## **Planning Objection**

Application Reference: 2025/62/93543/W

Site: land at, former Clough Mill, Clough Road, Slaithwaite, Huddersfield, HD7 5DB

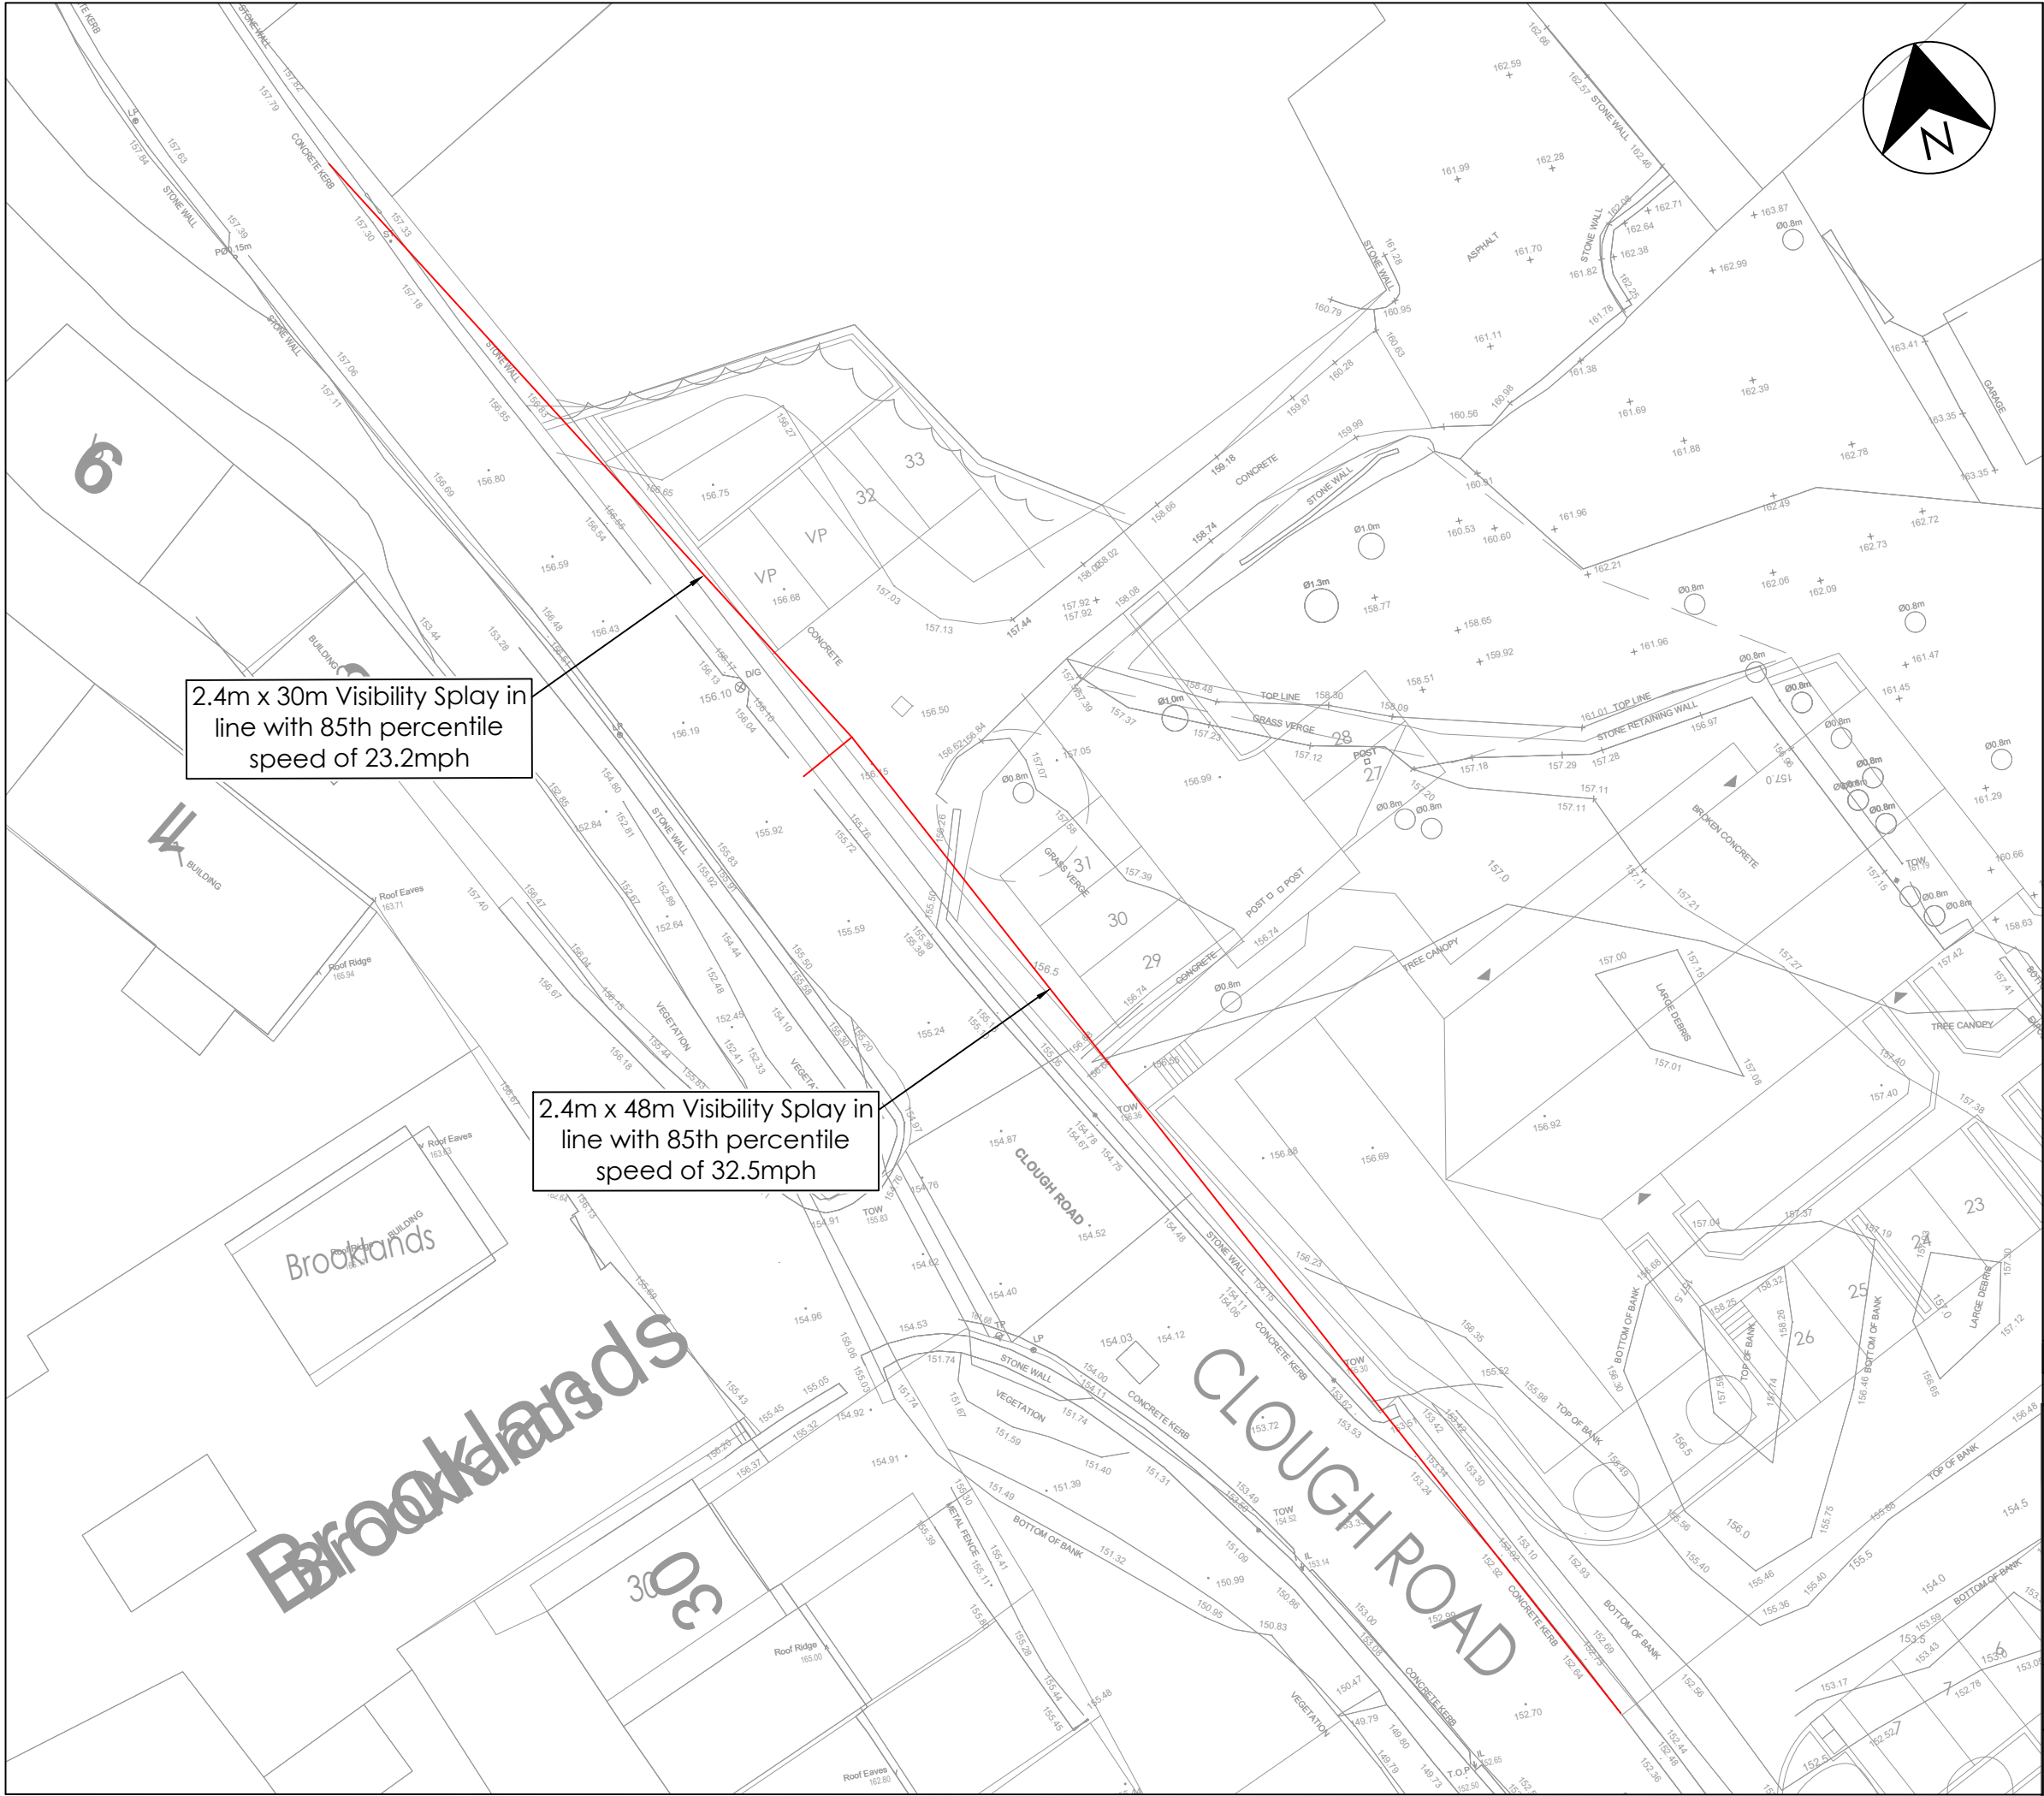
- The narrow, broken-white-line section of Clough Road. The proposed access to the site comes out onto a narrow section of Clough Road where 2 vehicles are unable to pass at the same time.
- The blind bend immediately North of the proposed access.
- Frequent unreported minor accidents further north where Clough Road narrows, well known to local residents.

There is no vehicle-to-vehicle passing analysis for the narrowest section of Clough Road, no assessment of visibility splays at the bend, and no pedestrian safety appraisal.
